**KITTITAS COUNTY**  
**DEPARTMENT OF PUBLIC WORKS**

**MEMORANDUM**

TO: Kari Braniff, Community Development Services  
FROM: Christina Wollman, Planner II *CW*  
DATE: August 19, 2008  
SUBJECT: Johnson-Hink Short Plat SP-08-35

JOHNSON-HINK SHORT PLAT
PART OF SECTION 24, T. 17 N., R. 19 E., W.M.
KITTITAS COUNTY, WASHINGTON

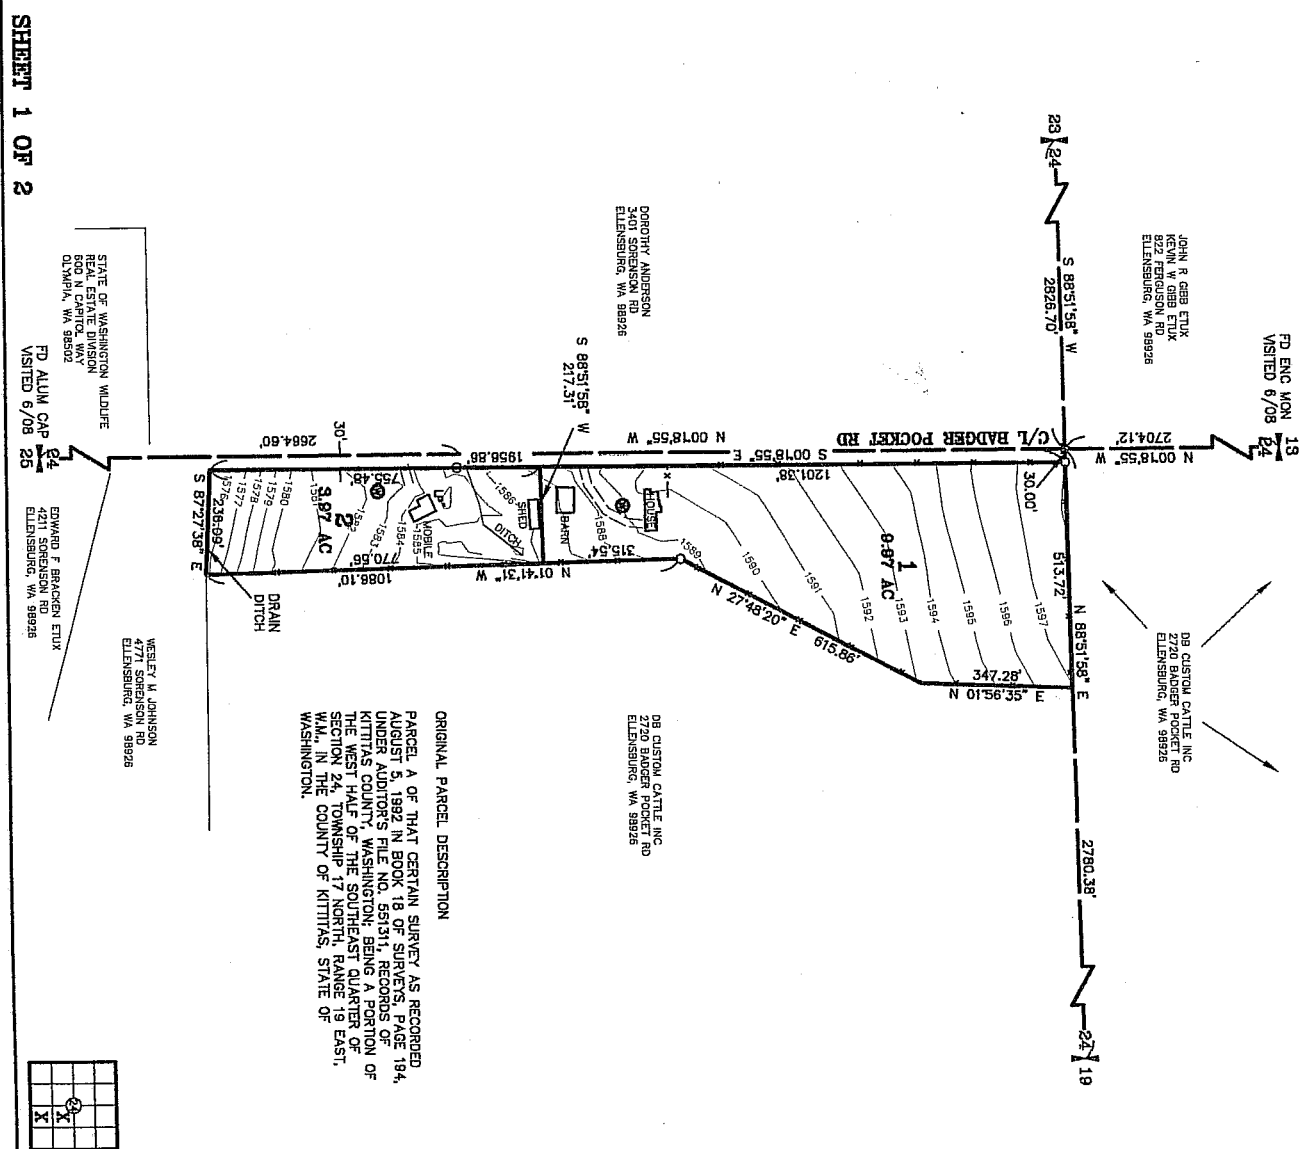
1. Access: Lots 1 and 2 shall be accessed with the existing accesses.  
Single-Use Driveway: A single-use access shall serve no more than one lot. See Kittitas County Road Standards, 9/6/05 edition.

- a. The roadway shall be a minimum of 8' wide with gravel surface.
  - b. Maintenance of driveway approaches shall be the responsibility of the owner whose property they serve. The County will not maintain accesses.
